SECTION 4.55 (1A) APPLICATION TO AMEND SSD 10437 - WATERLOO METRO QUARTER OSD SOUTHERN PRECINCT

This letter has been prepared by Urbis on behalf of WL Developer Pty Ltd (the applicant) with regards to a Section 4.55(1A) application to modify State Significant Development (SSD) Waterloo Metro Quarter OSD Southern Precinct SSD-10437.

The modification application seeks for minor internal and external design changes to Building 3 and the landscaping. The majority of the proposed changes are internal and considered to be minor. The external changes relate to minor landscape changes, configuration of rooftop plant and inclusion of additional louvres.

DRAWING  
LANDSCAPE PLAN  
LEVEL 02 COMMUNAL TERRACE

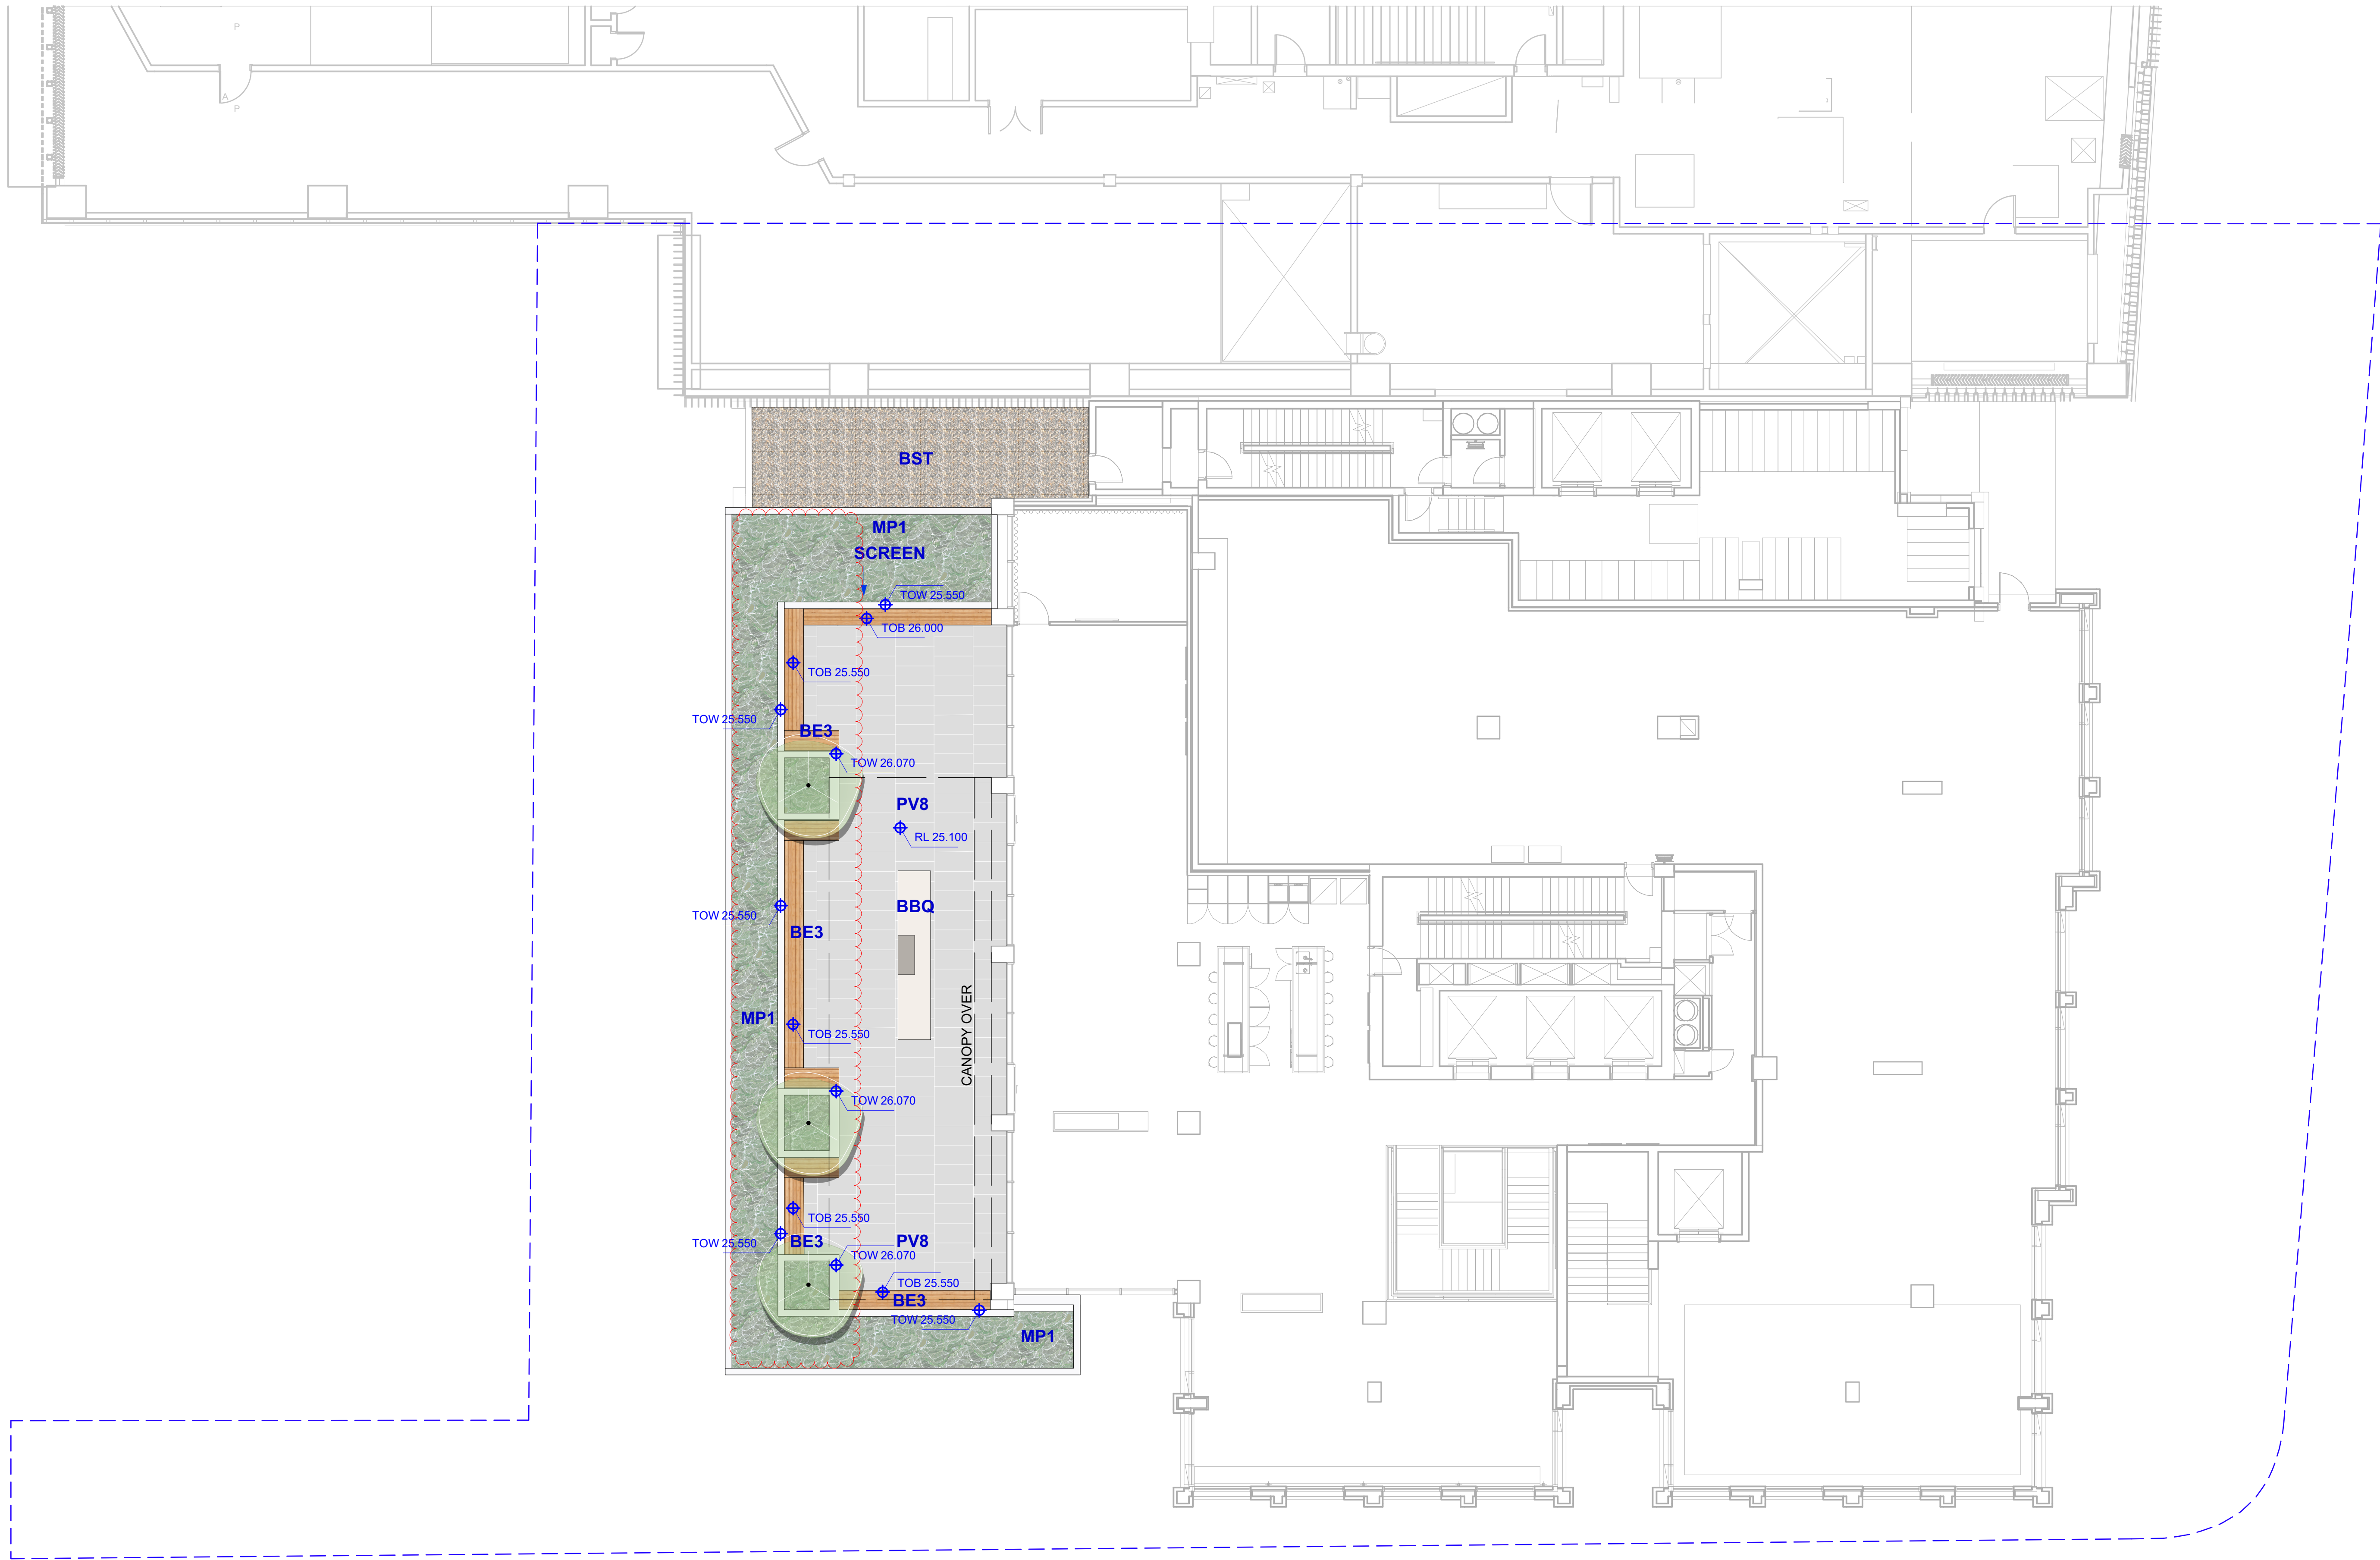
- Landscape changes public domain area around Building 3, including:
 - Relocation of proposed trees and reconfiguration of garden bed
 - Revised awning location
 - Reconfiguration of seating bench locations
 - Revised stair width
 - Addition of landscaped area at the rear of the Waterloo Congregational Church (WCC)
- Landscape changes to Cope Street Plaza, including:
 - Removal of indicative canopy
 - Reconfiguration of garden bed
 - Reconfiguration of seating bench locations
 - Reconfiguration of the shared way with additional landscaping to further improve pedestrian safety.
- Minor changes to Building 3 Level 2 Terrace.

Sheet title
General Arrangement Plan
Mezzanine Plan

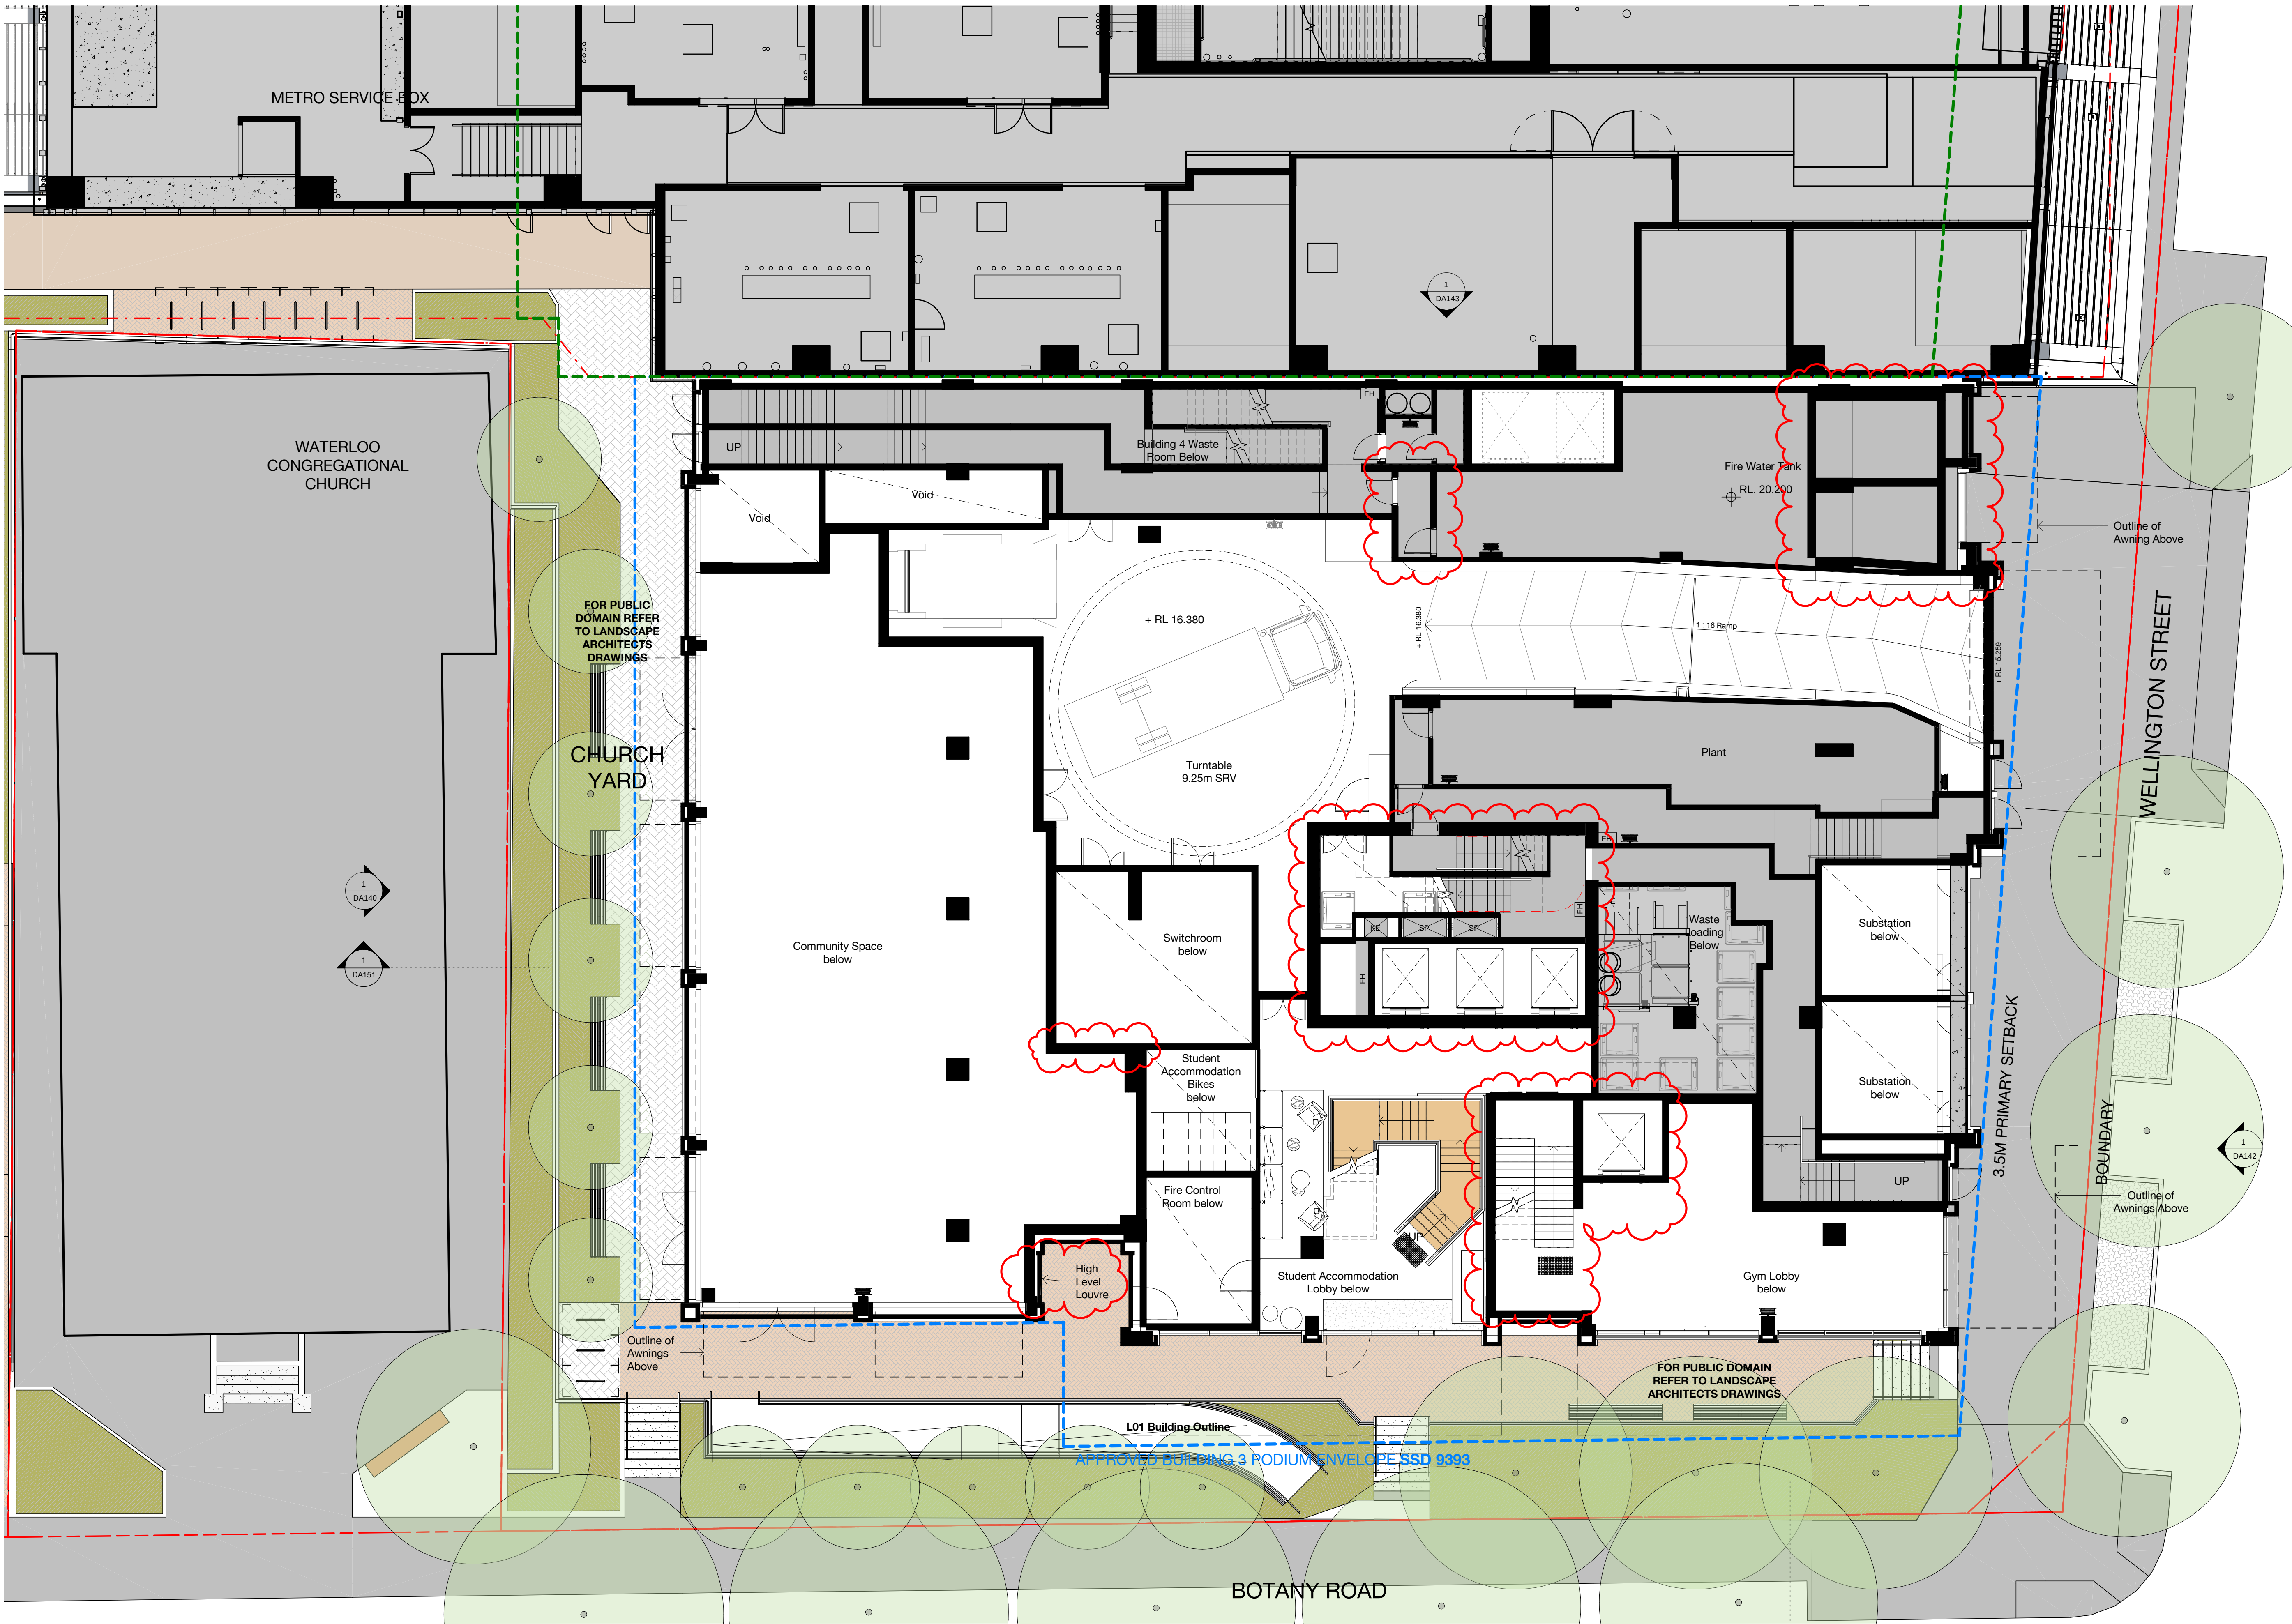
- Revise roof plant zones
 - Increase height of plant zones, not exceeding the approved Concept building envelope (RL96.9) (see below comparison of plans);
- Addition of louvre for ventilation on western elevation to Level 24 lift core
- Additional service doors to podium roof
- Addition of louvres to podium of the mezzanine level and Level 1.
- Addition of louvres to northern elevation of the ground level and Level 2
